REFUSAL OF PLANNING PERMISSION

APPLICATION NO. 2009/0214

Proposal Erection of 1 detached dwelling (Resubmission)
At Land Adj to 26 Millmount Road, Hoyland, Barnsley

title SECTION & ELEVATIONS		
client	MR. M. MONFREDI	date: JUN 08
		scale: 1:50 1:100
project PROPOSED DEVELOPMENT MILLMOUNT ROAD, HOYLAND, BARNSELEY		
job no.:	dr. no.:	rev.
28/092	3	A

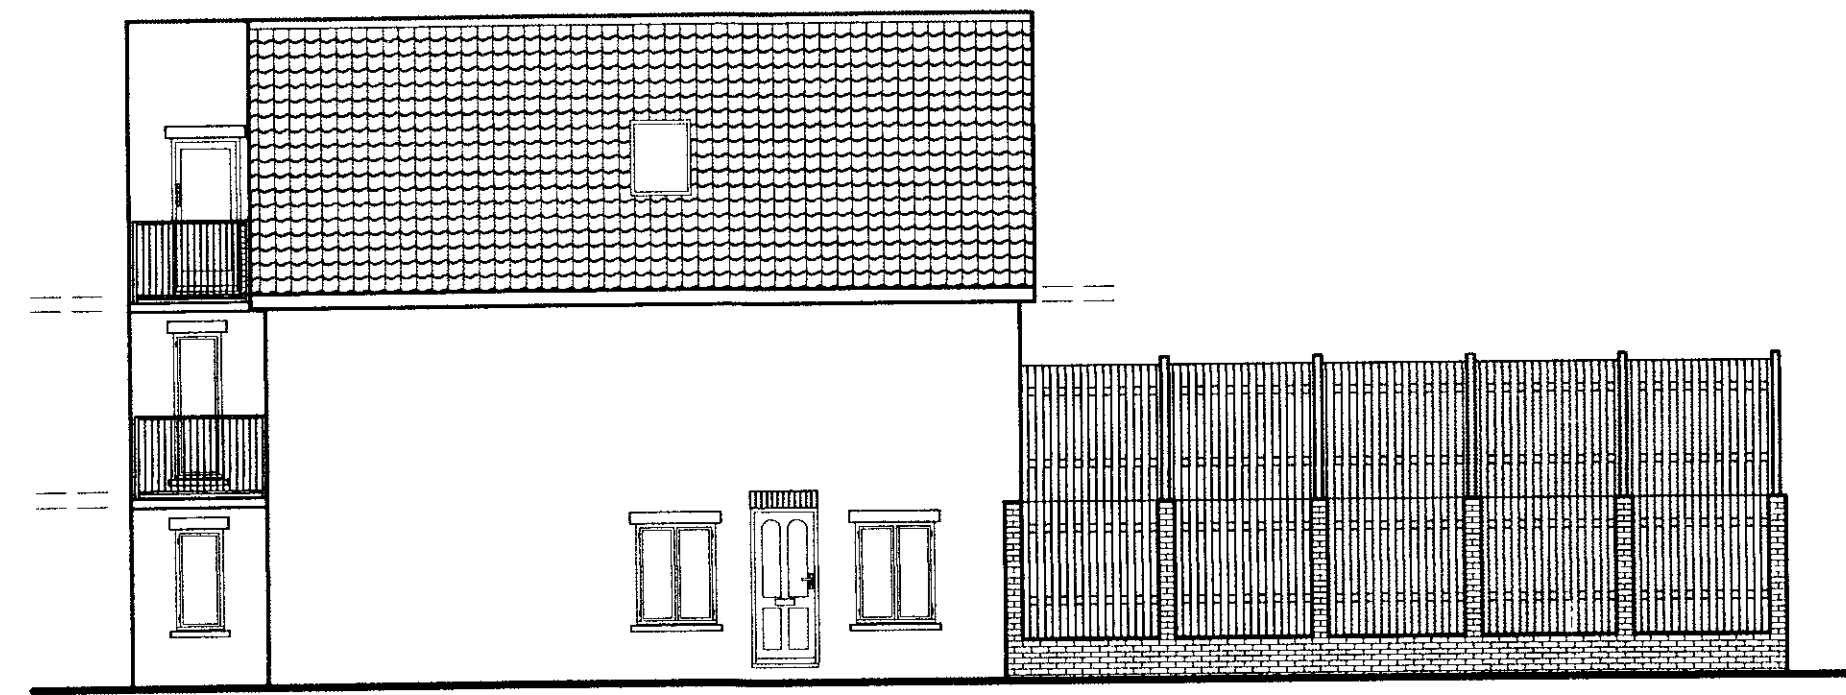
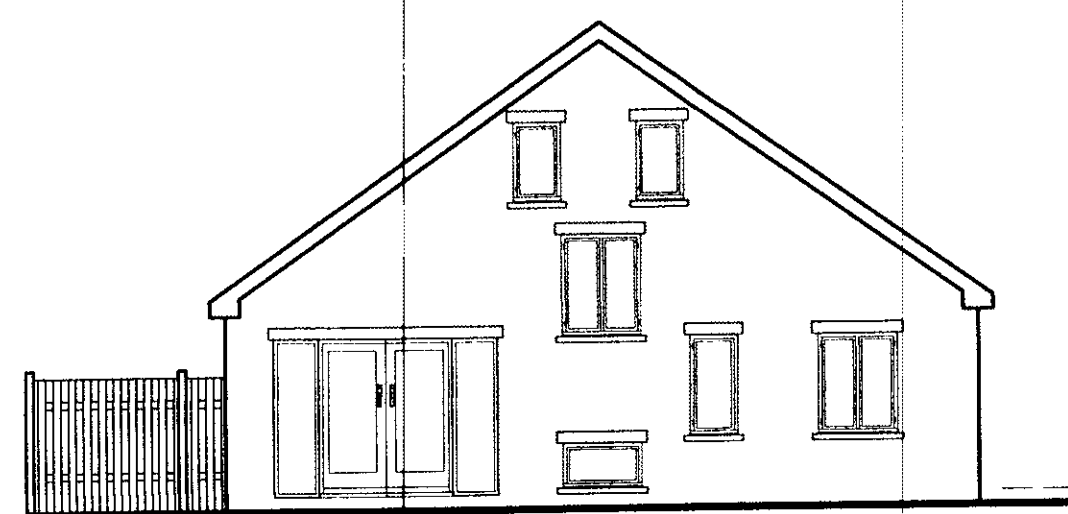
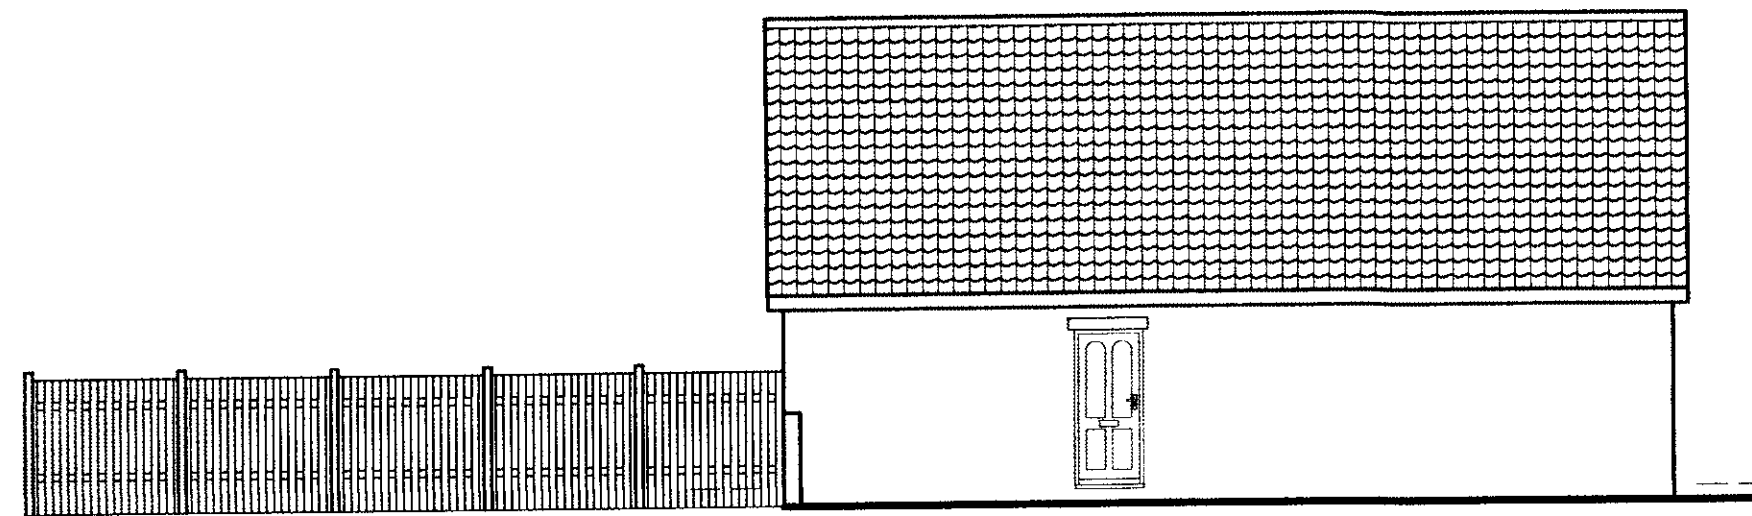
- 1 In the opinion of the Local Planning Authority, the proposed balconies would be materially detrimental to the amenities of the occupants of the adjoining dwellings due to increased levels of overlooking and unreasonable loss of privacy contrary to Unitary Development Plan Policy H8E and the Council's Supplementary Planning Guidance Note 4.

- 2 In the opinion of the Local Planning Authority, the proposed store room and high level fencing would be materially detrimental to the amenities of the occupants of the neighbouring apartments by reason of its overbearing impact contrary to Unitary Development Plan Policy H8E and the Council's Supplementary Planning Guidance Note 4.

- 3 In the opinion of the Local Planning Authority the proposed balconies, fenestration, store room and high level fencing would be contrary to Policy H8E of the Unitary Development Plan and the Council's Supplementary Planning Guidance Note 4 in that their design and elevated position would be architecturally inconsistent with the character of the property to the detriment of visual amenity.
